Your Ref: OWPC6018
Our Ref: K/17/15/HH 06-05-2015
Please ask for:
Ross Leal

2 Storey side & rear extensions with balconies, conversion of roof void to create En-suite Bedrooms including the insertion of 3no. new dormers, roof alterations, new Garage outbuilding with ancillary accommodation & link to main house & swimming pool.

Russet House Gorse Avenue Kingston Gorse Kingston

Thank you for your internet representation made on 12th June 2015 which has been recorded as '**an objection**' with the comments as follows:

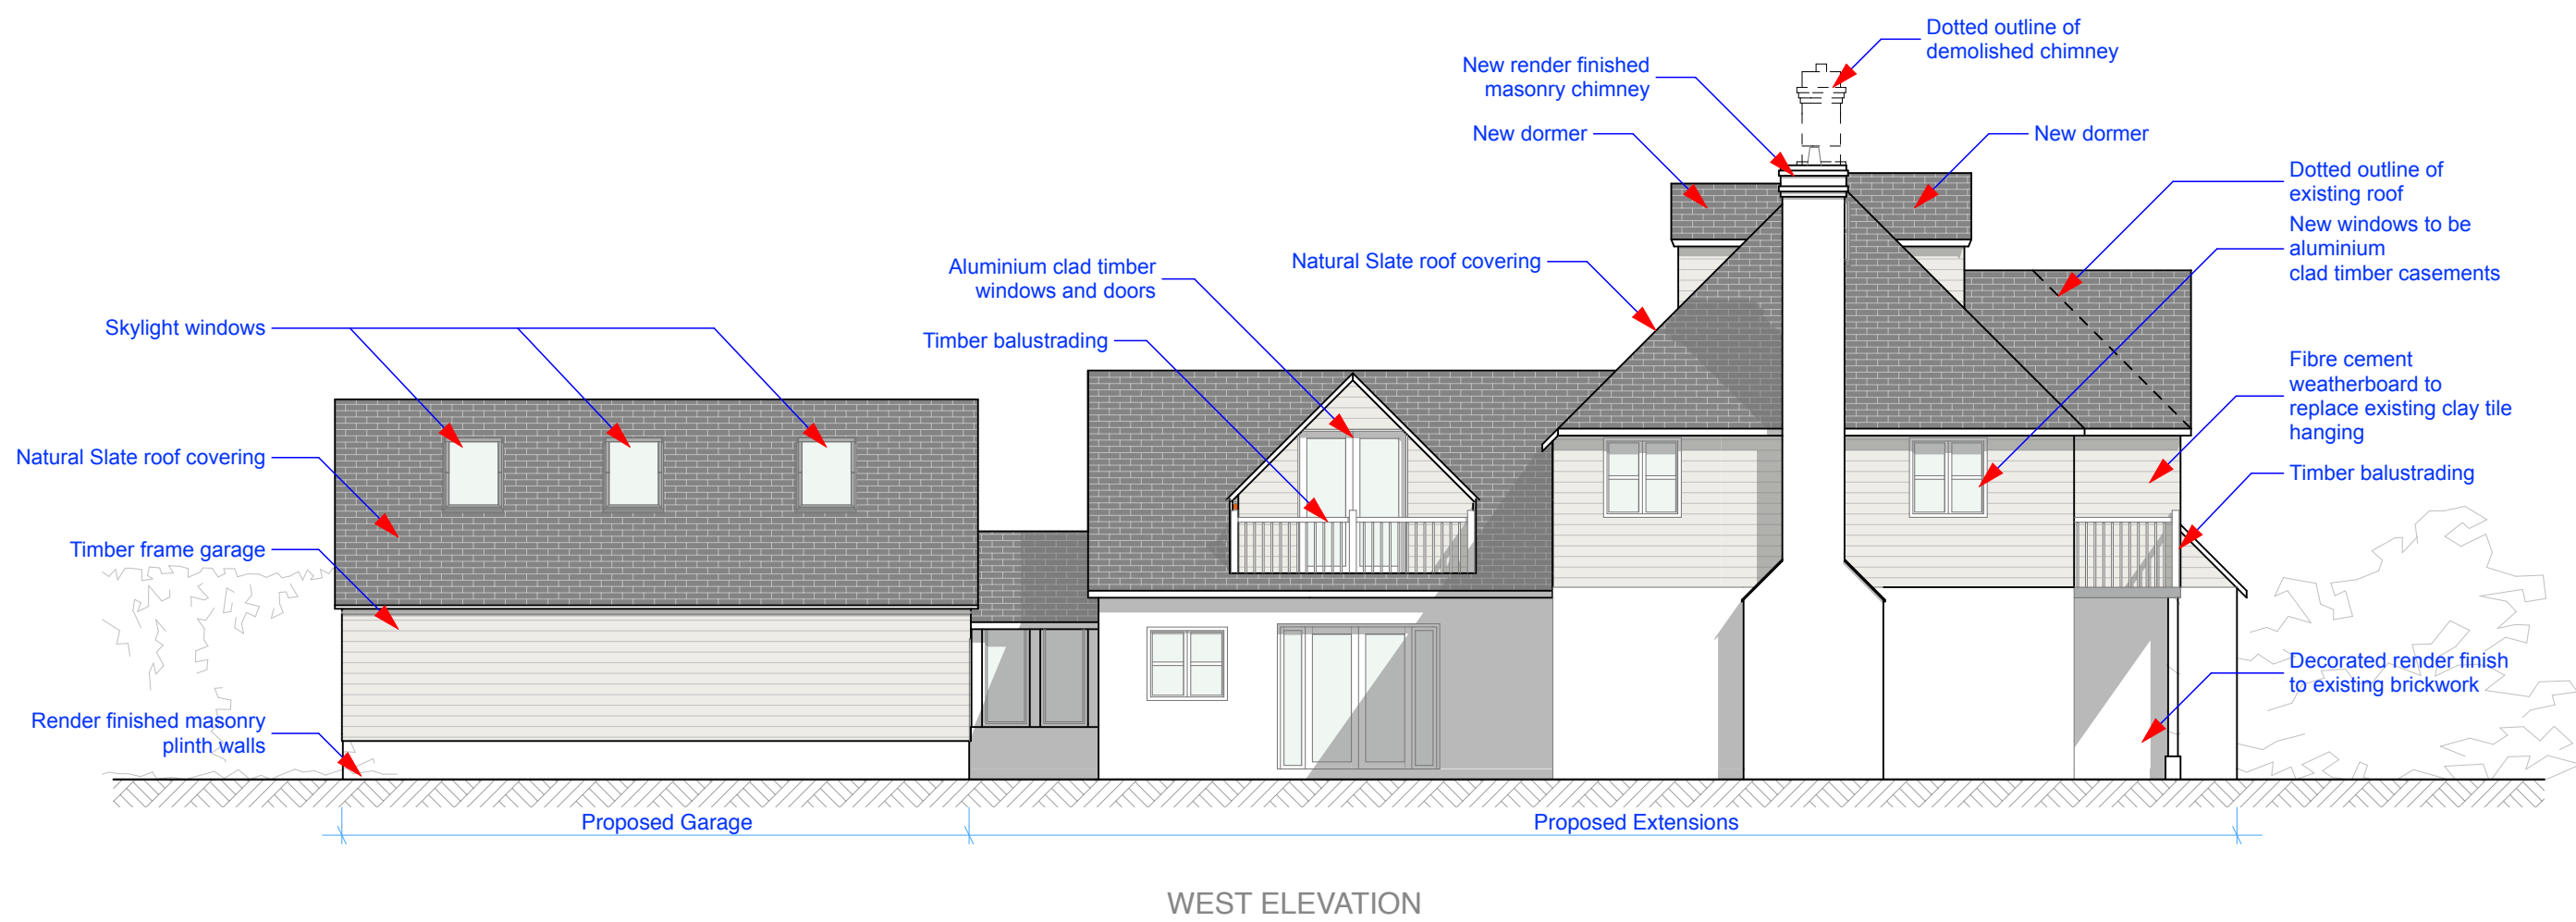
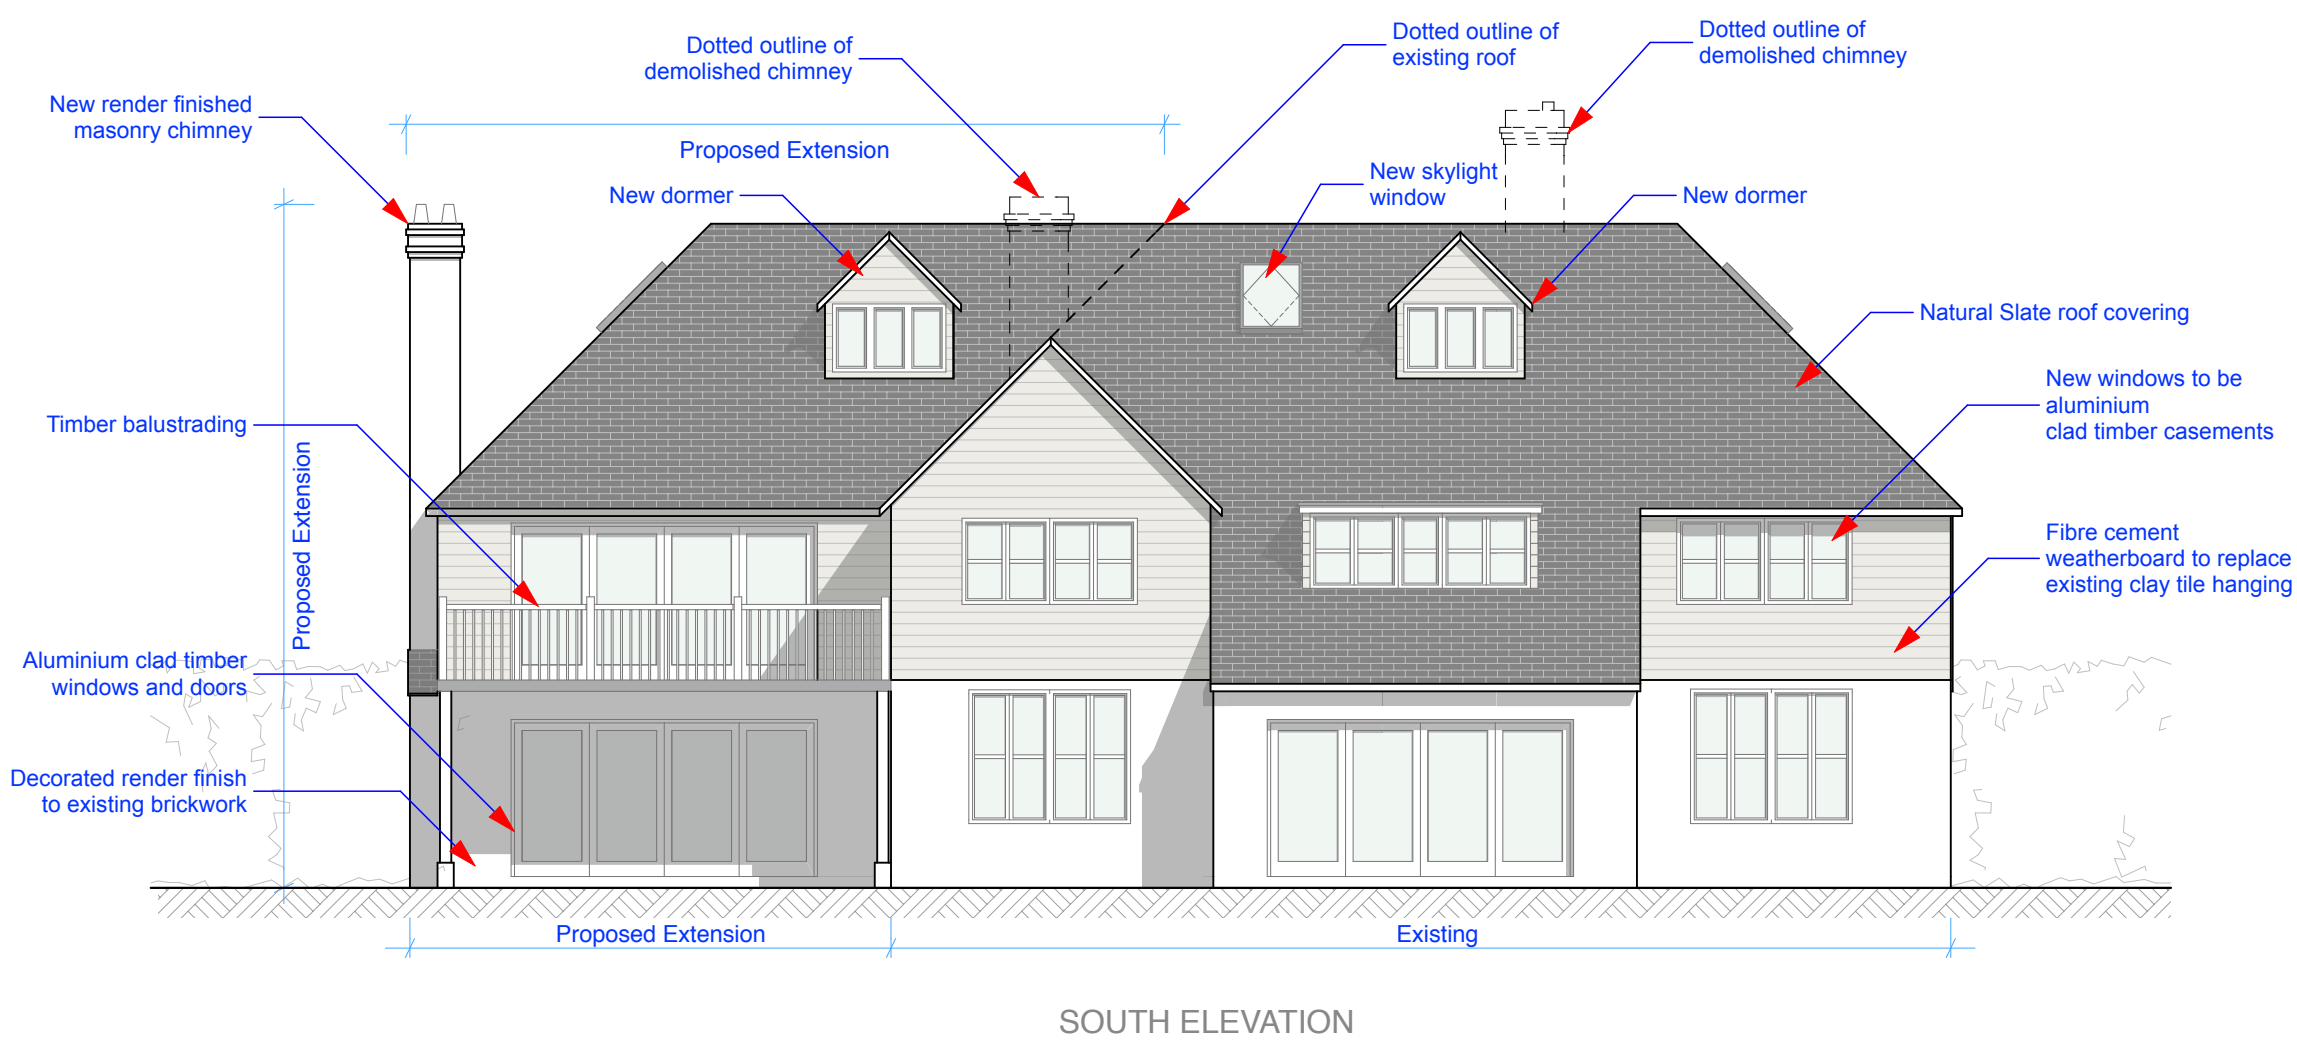
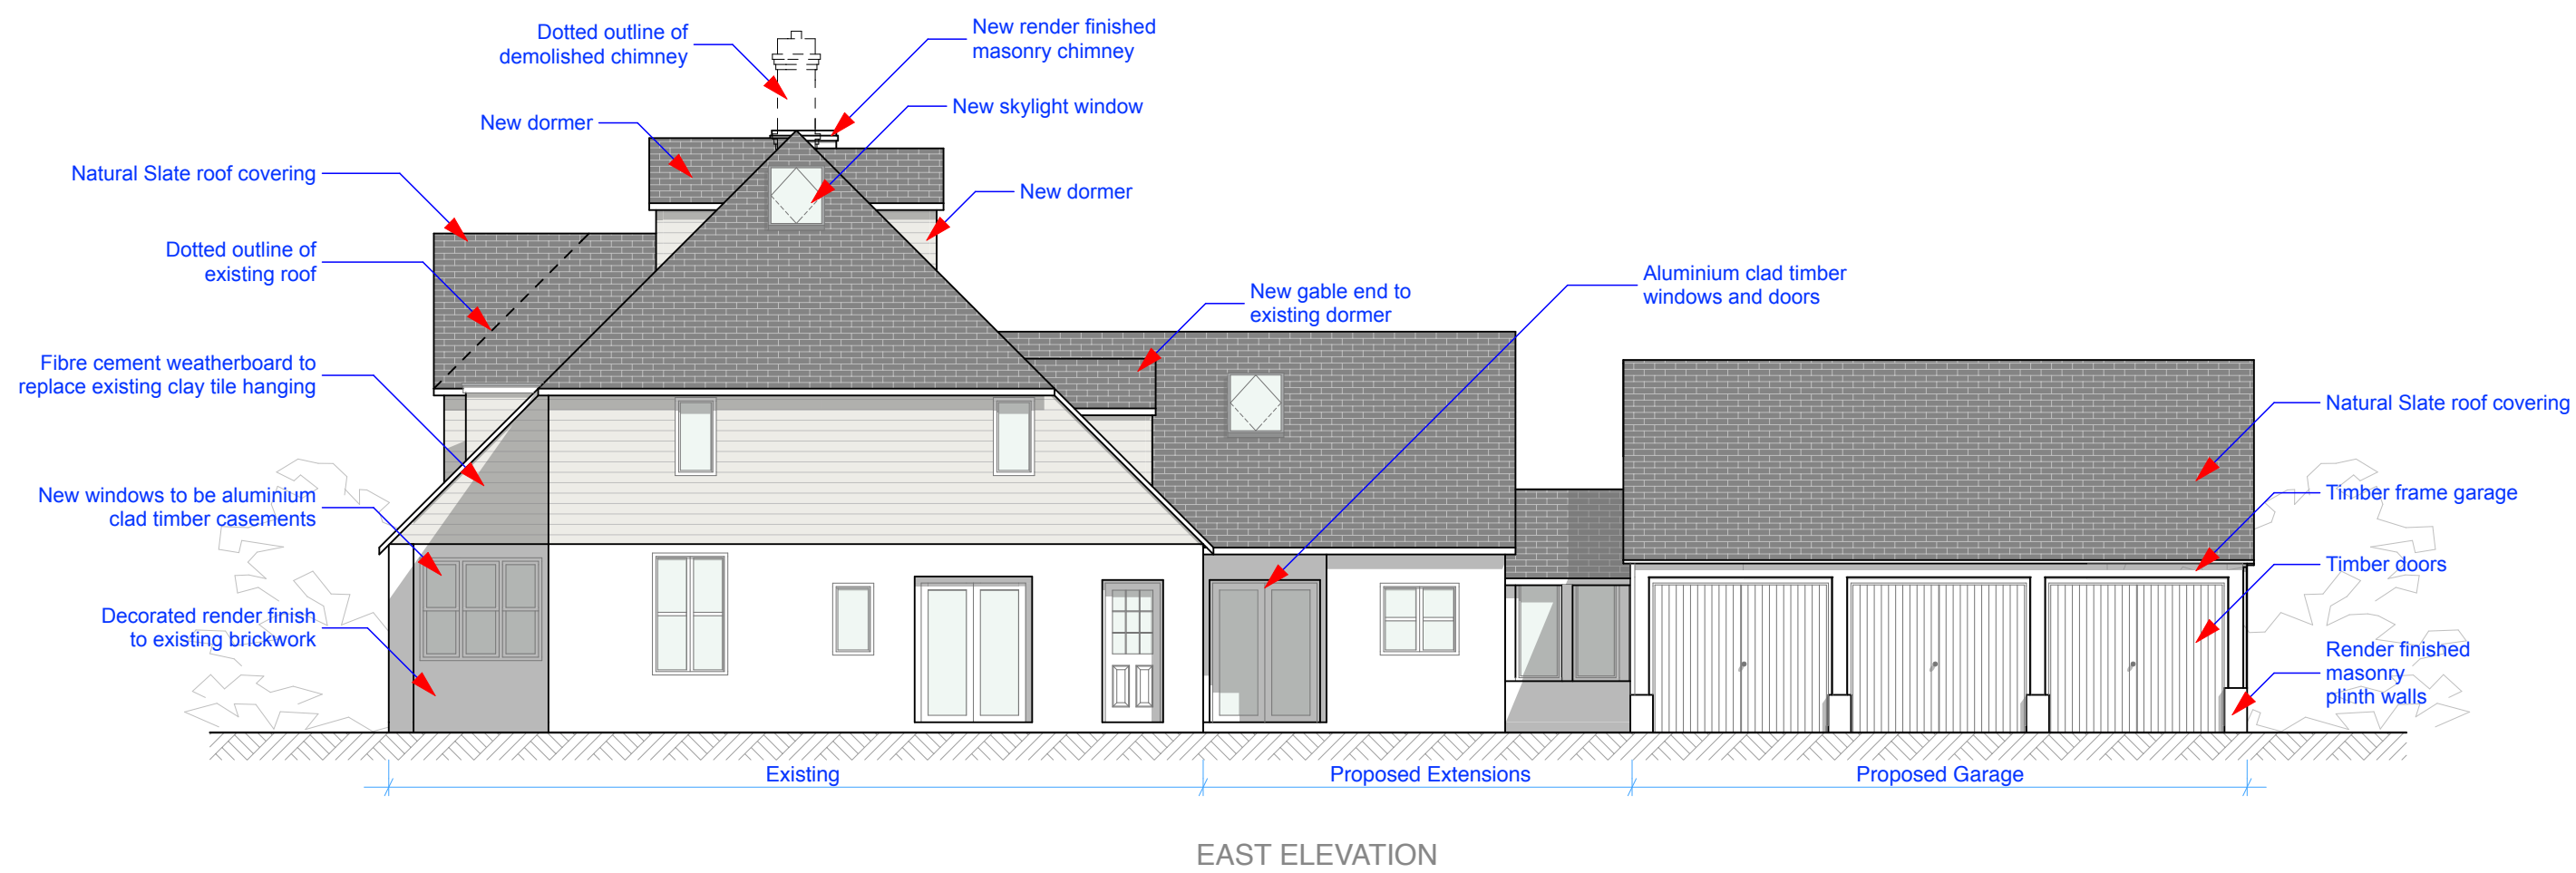
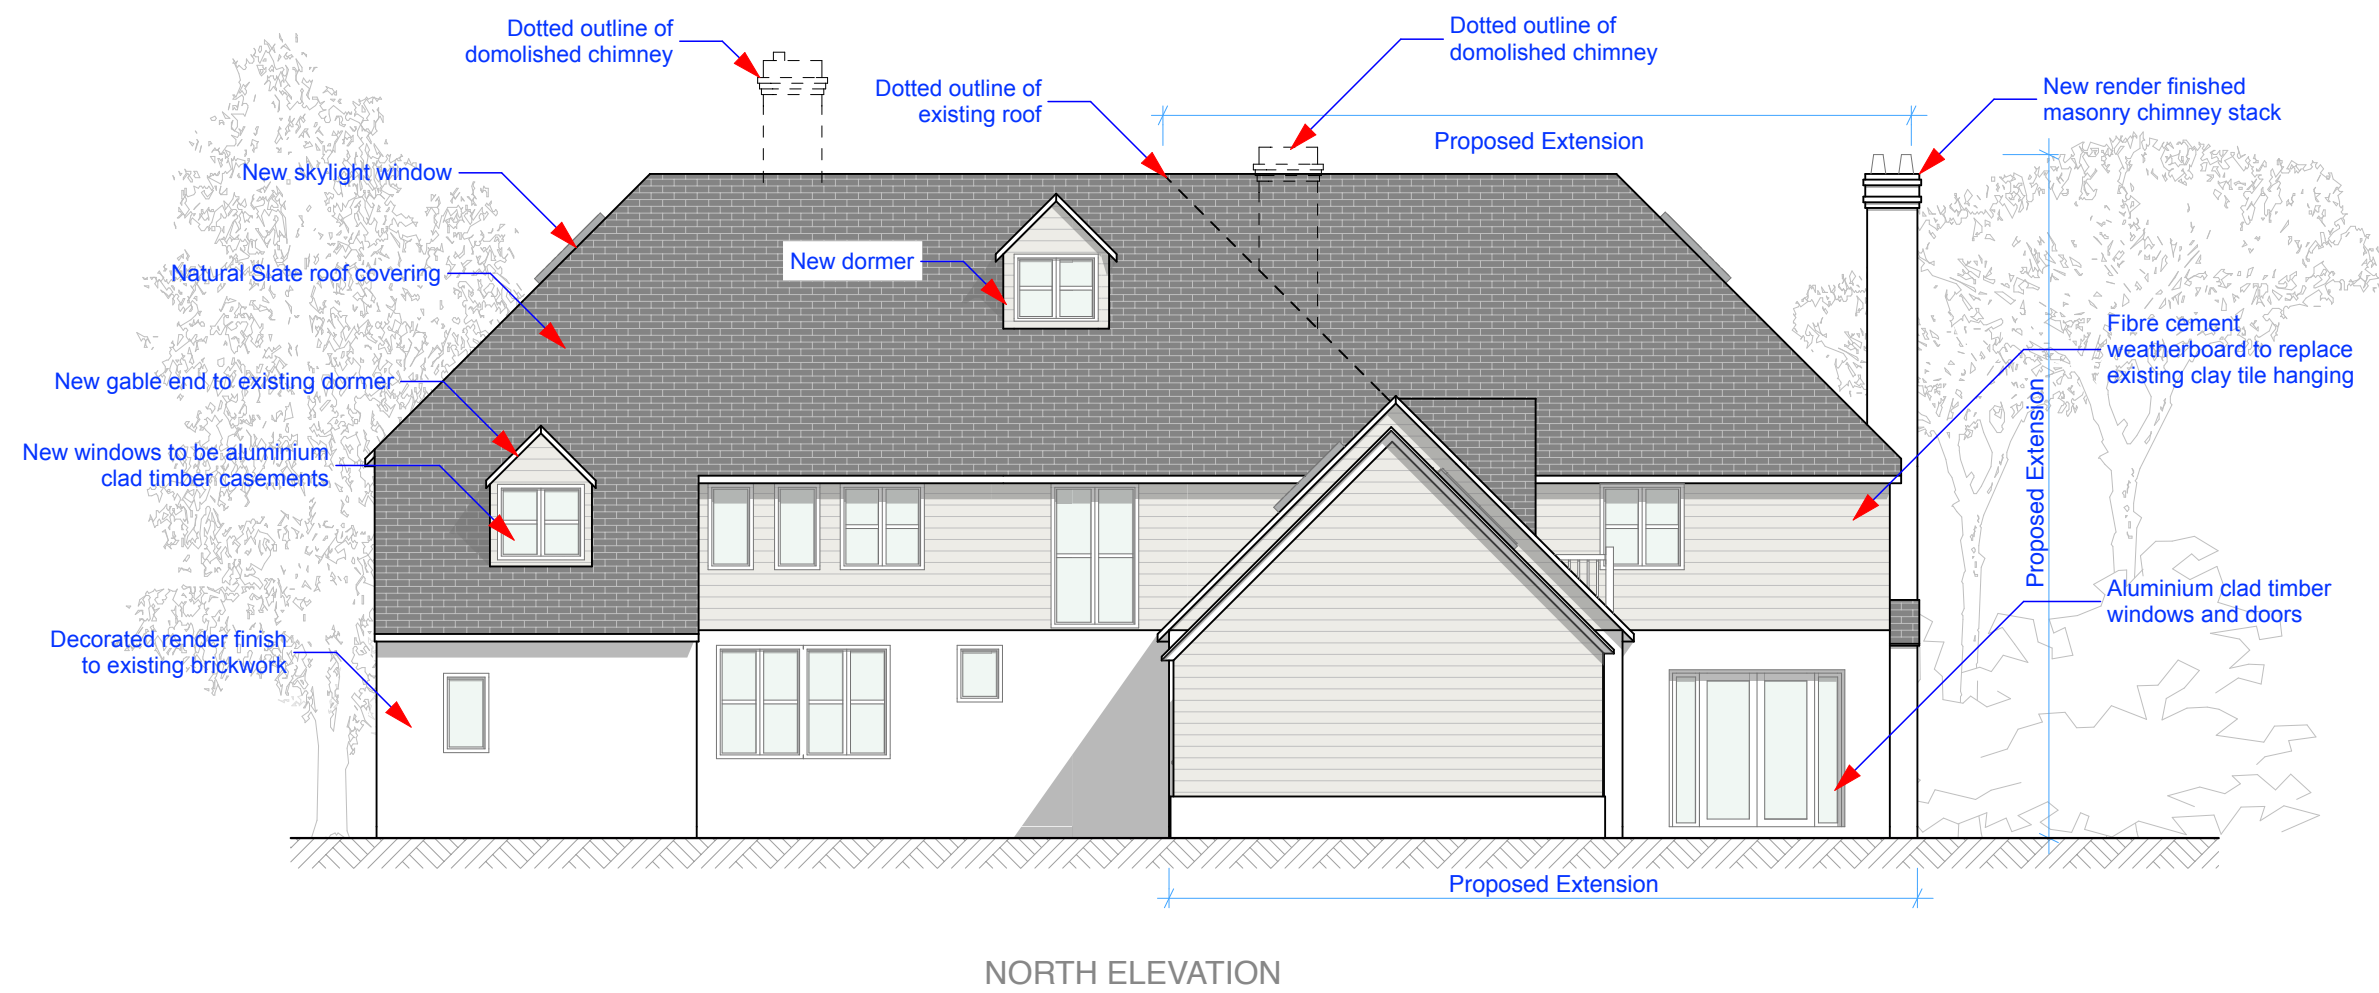
The proposed dormer windows and skylight would add a third storey to the southern aspect of the applicants' house which would therefore overlook our home which has only two storeys. This would compromise our privacy as we have many windows on the ground and first floors all at a lower level to the proposed dormers and skylight windows.

The front apron of our house is presently not overlooked - a privacy and characteristic that we also appreciate and would not like to lose.
